OXFORDSHIRE COUNTY COUNCIL'S RESPONSE TO CONSULTATION ON THE FOLLOWING DEVELOPMENT PROPOSAL

Application no: 13/01811/OUT

Location: OUTLINE - Up to 60 dwellings and public open space with associated works

Transport

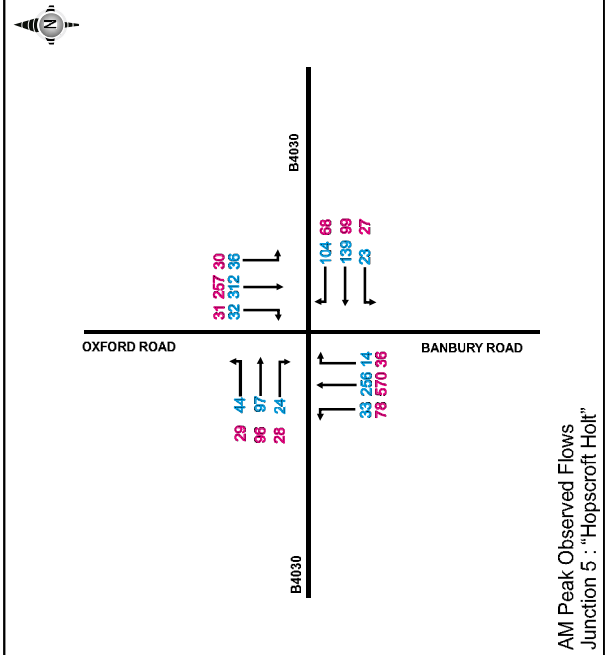
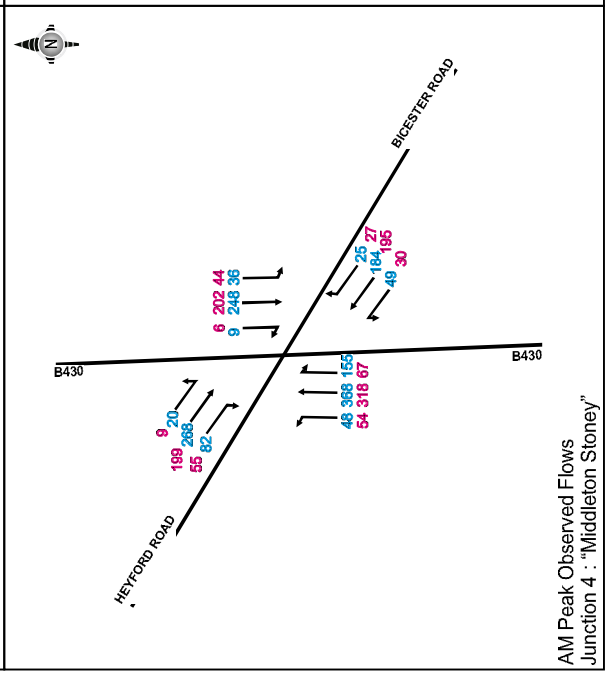
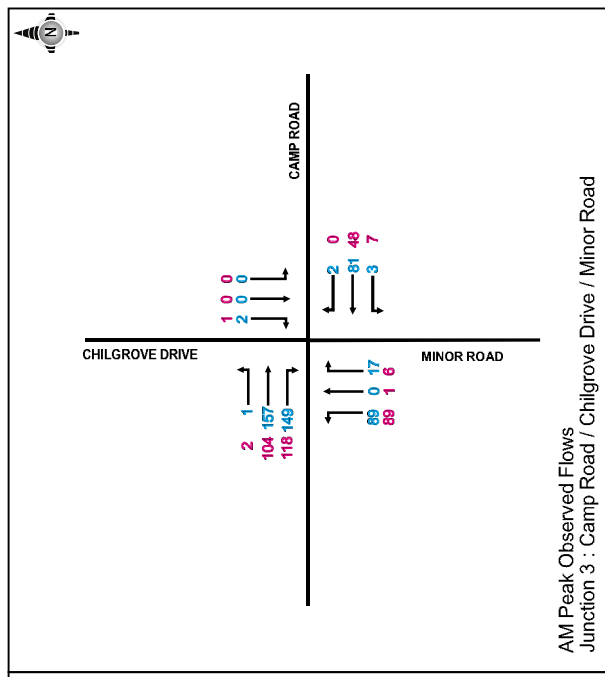
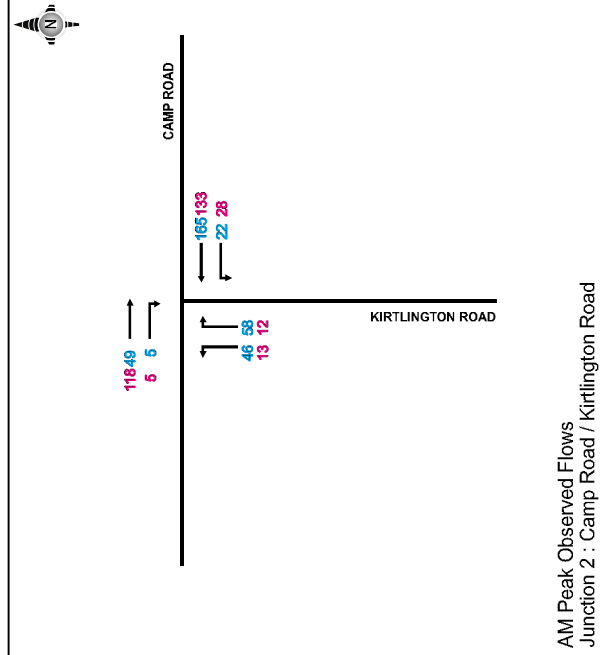
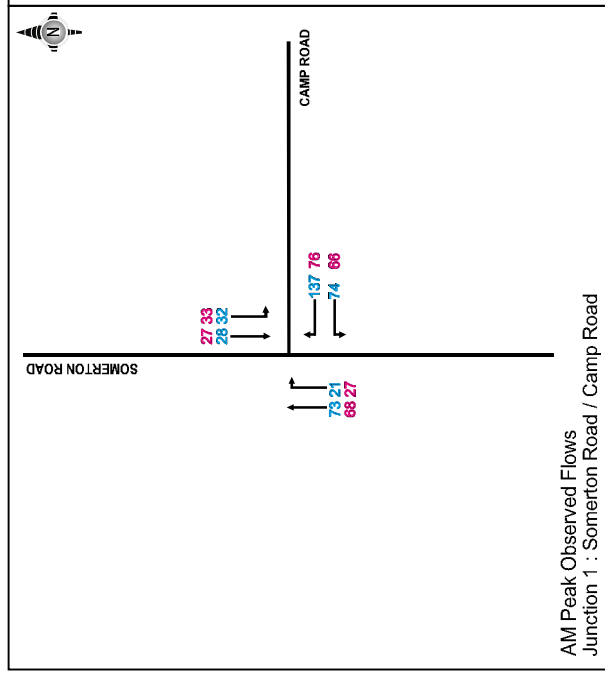
2. The proposal does not properly demonstrate the impact of the 60 dwellings, rather it seeks to provide a *comparative* impact of 2006 traffic levels from the Arup TA for the wider Heyford site with 2013 traffic levels. This approach is not acceptable. The TA in question is seven years old, some data (e.g. the 2006 extant development traffic – see point 3) is not clearly available, am and pm peak periods are not defined. This application does not consider committed developments that have been granted consent since 2007. For the A4260/B4030 junction that is reported to show 230 additional vehicular movements in 2013 compared to 2006, this junction has not been assessed to see whether there are any network capacity, delay or safety issues, and no mitigation is proposed as a result of this application.

4. The applicant has used '2006+Heyford Park traffic' data to demonstrate that 2006 traffic flows at five junctions are generally lower in 2013. However section 3 above raises concerns with the ability to actually establish what the extant flows at Heyford were in 2006. If one does a similar comparison of the 2006 Arup base traffic data with 2013 surveys this indicates that for most cases cases 2013 peak traffic junction levels are generally higher. Given the above ambiguities over the exact level of traffic generation at Heyford in 2006, I request that a standard approach to assessing the impact of these 60 dwellings is taken and the application assessed on its merits.

It is not relevant to compare 2006 data with 2013 data to establish what the impact of 60 new dwellings will be. There are concerns with some of the historic data in any case, as outlined above. A standard assessment should be carried out for the 60 dwellings, and the impact of these dwellings mitigated by way of an appropriate financial contribution towards highways and transport improvements in the vicinity.
